Case Officer: Catherine Harker **Recommendation:** Approve

Applicant: Sir Stephen Gomersall

Proposal: To move existing window on rear elevation by 50-60 centimetres
(following permission granted in decision of 9 October on application
20/02076/LB)

Stickleys House Sibford Gower OX15 5RT Kitchen Rear Window

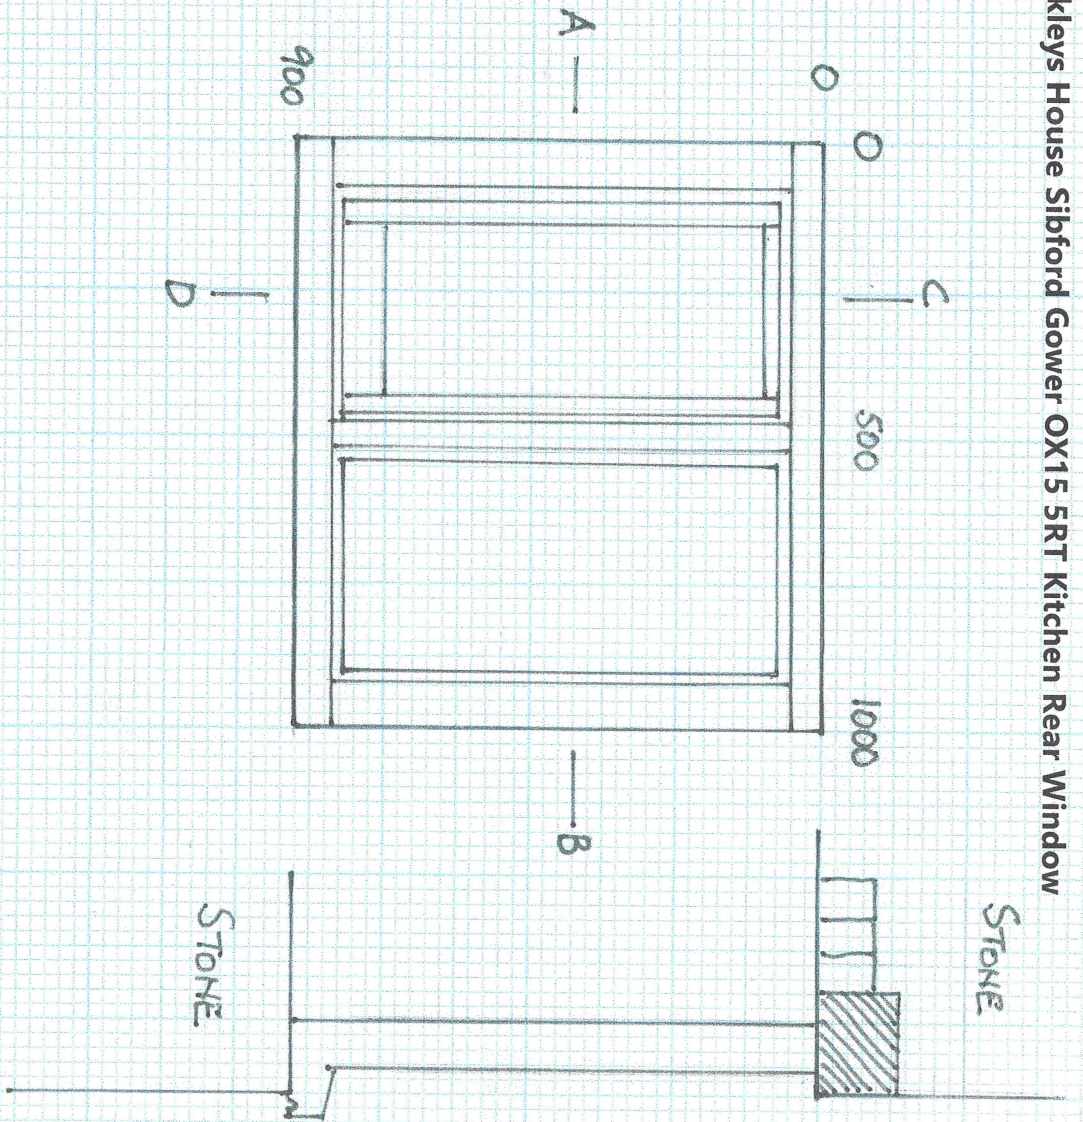
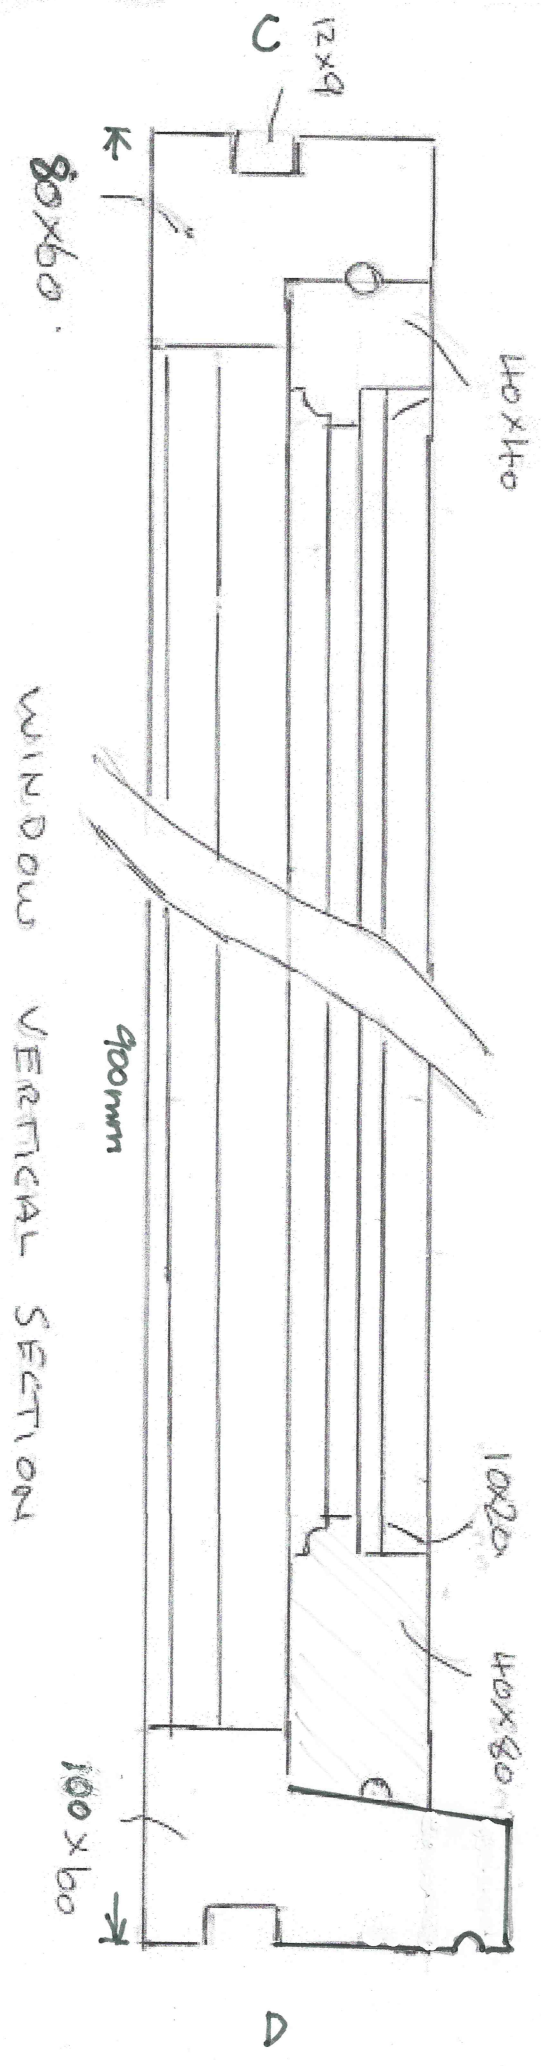
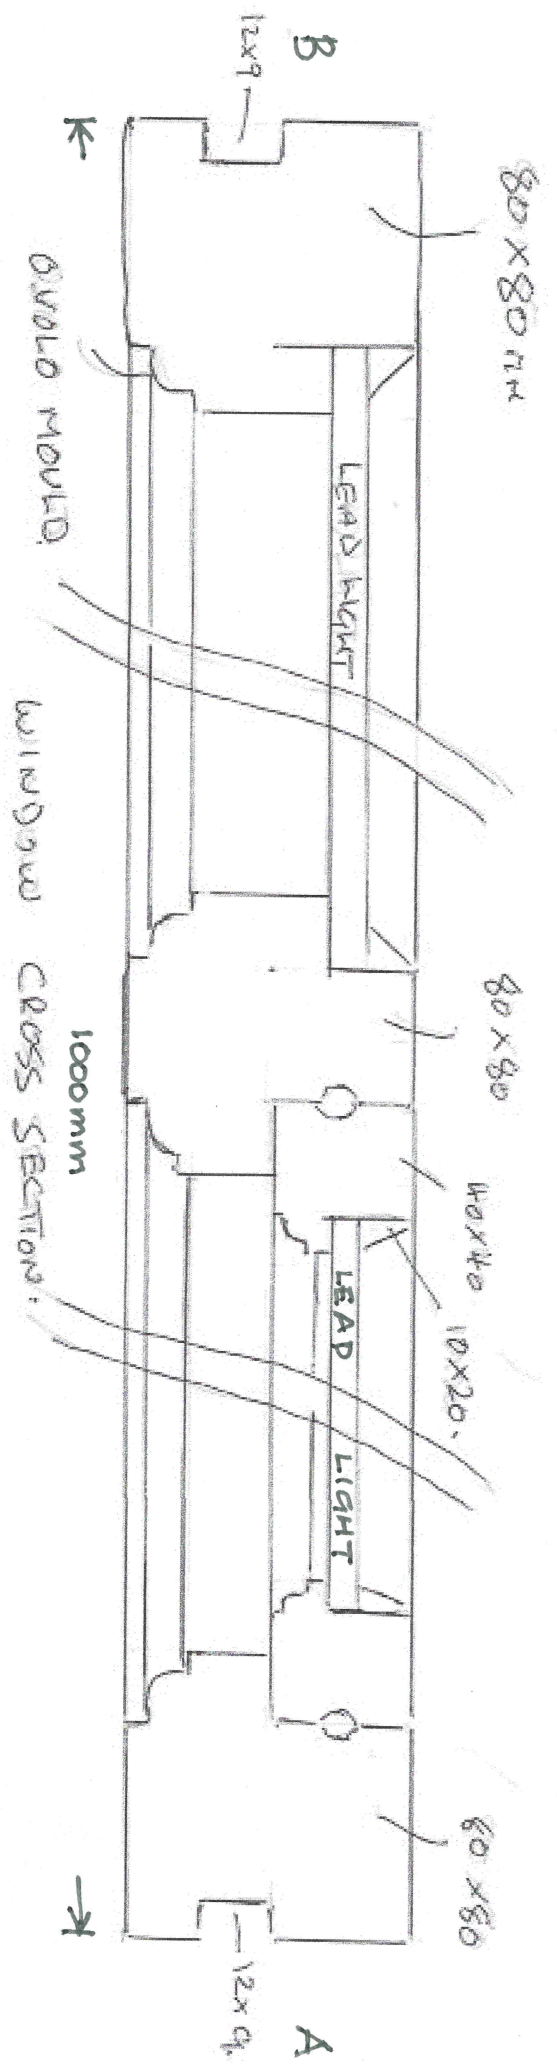
- 6.8. A method statement and the design of the new window should be submitted. This could be dealt with by condition, but the applicant may find it preferable to submit the information prior to determination.

- 8.7. The joinery details submitted are considered acceptable as a replacement for a modern window.
- 8.8. The Conservation Officer has stated that the proposals would result in some minor harm to the historic fabric of the listed building, but that this would not significantly impact on the historic significance of the building. The new window is considered to be in keeping with the historic character of the listed building due to its more traditional proportions.

- 6.10. The Method Statement and Joinery details provided are considered to be acceptable

Drawing No:	Date	Scale
6601-08b	14/5/2019	As indicated@A1

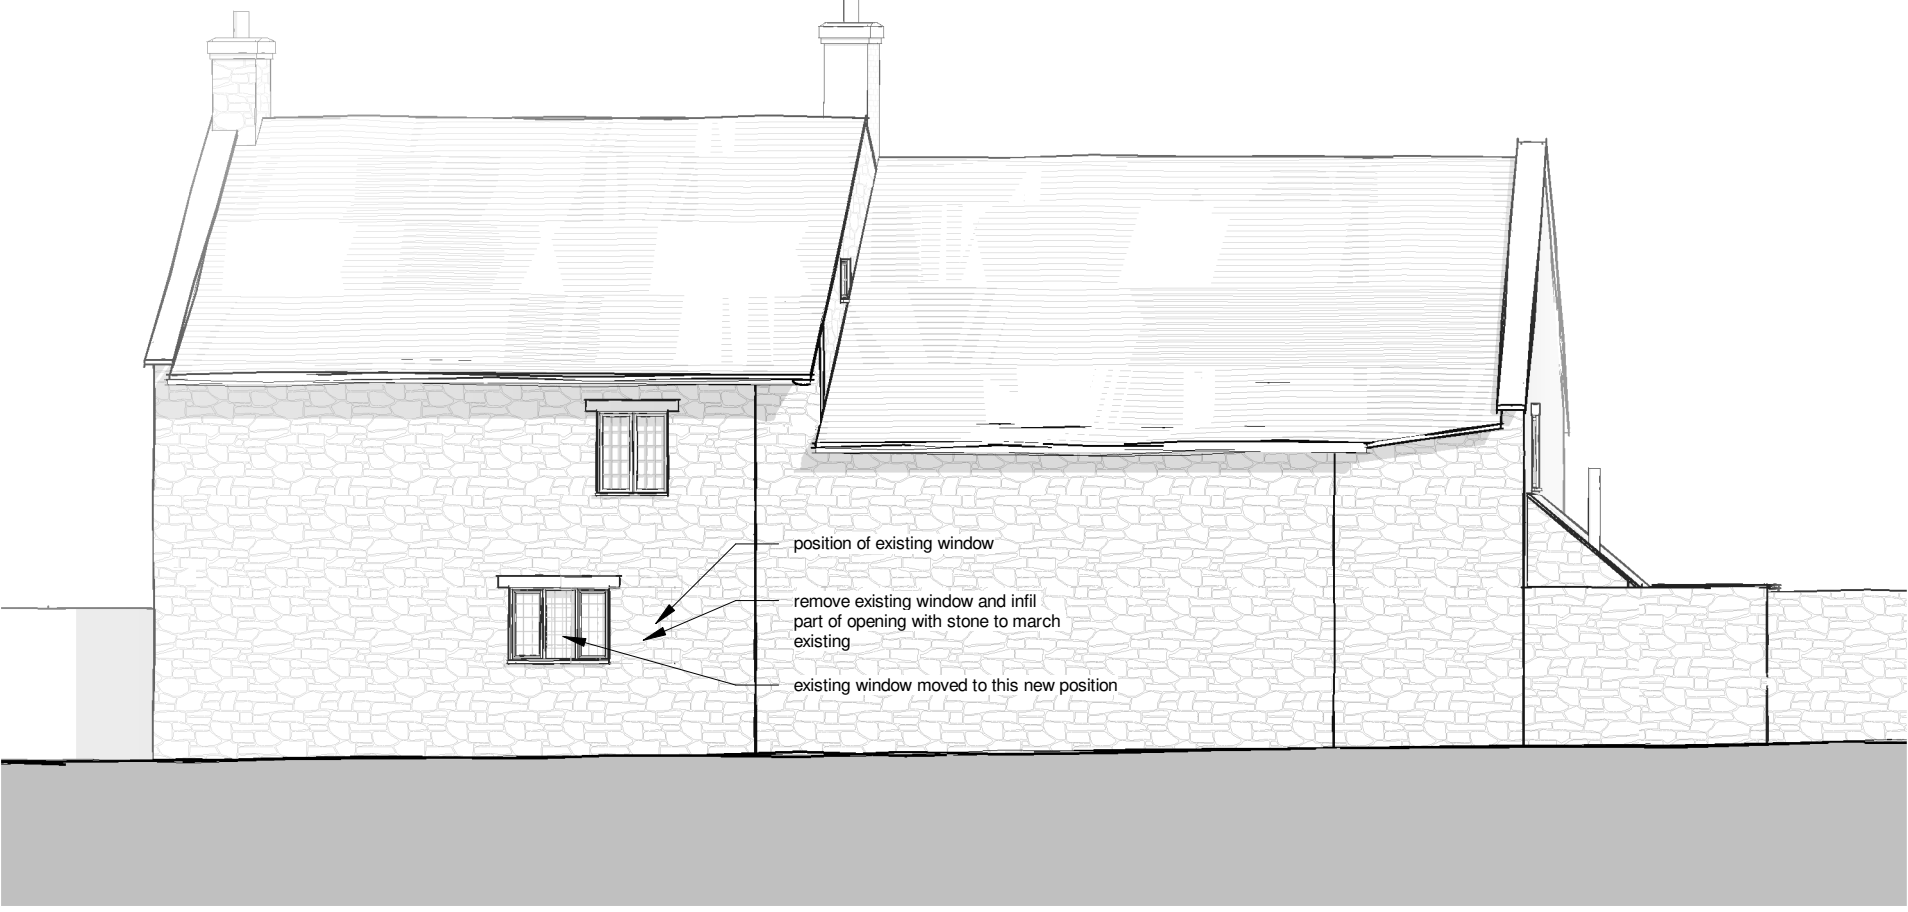
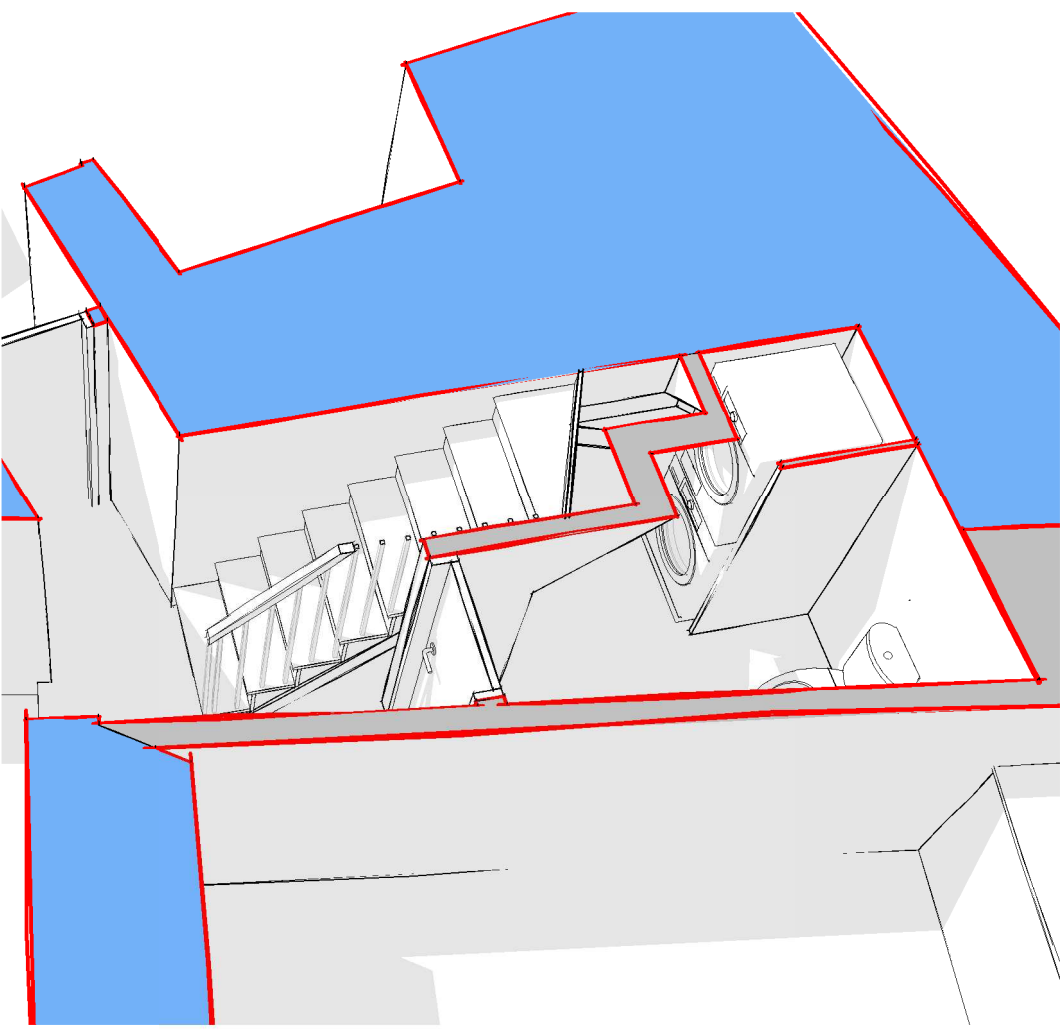
- 6.5. It would be preferable for the window to remain in its current location and be subdivided (given that the window itself is not of historic merit), but the applicant's proposals have changed.

- 6.7. It is not considered that the very low level of harm caused should lead to a refusal. It is understood that the proportions of the window are now proposed to change from the existing (which is potentially a benefit as the proportions look more traditional).

8.5. The window in question is clearly modern but sits beneath what appears to be a historic lintol, which implies that the opening may also be historic.

- 8.10. Although the Conservation Officer would have preferred the windows to remain its current location it is not considered that that any harm would be significant enough to require a refusal and a positive recommendation is therefore made.
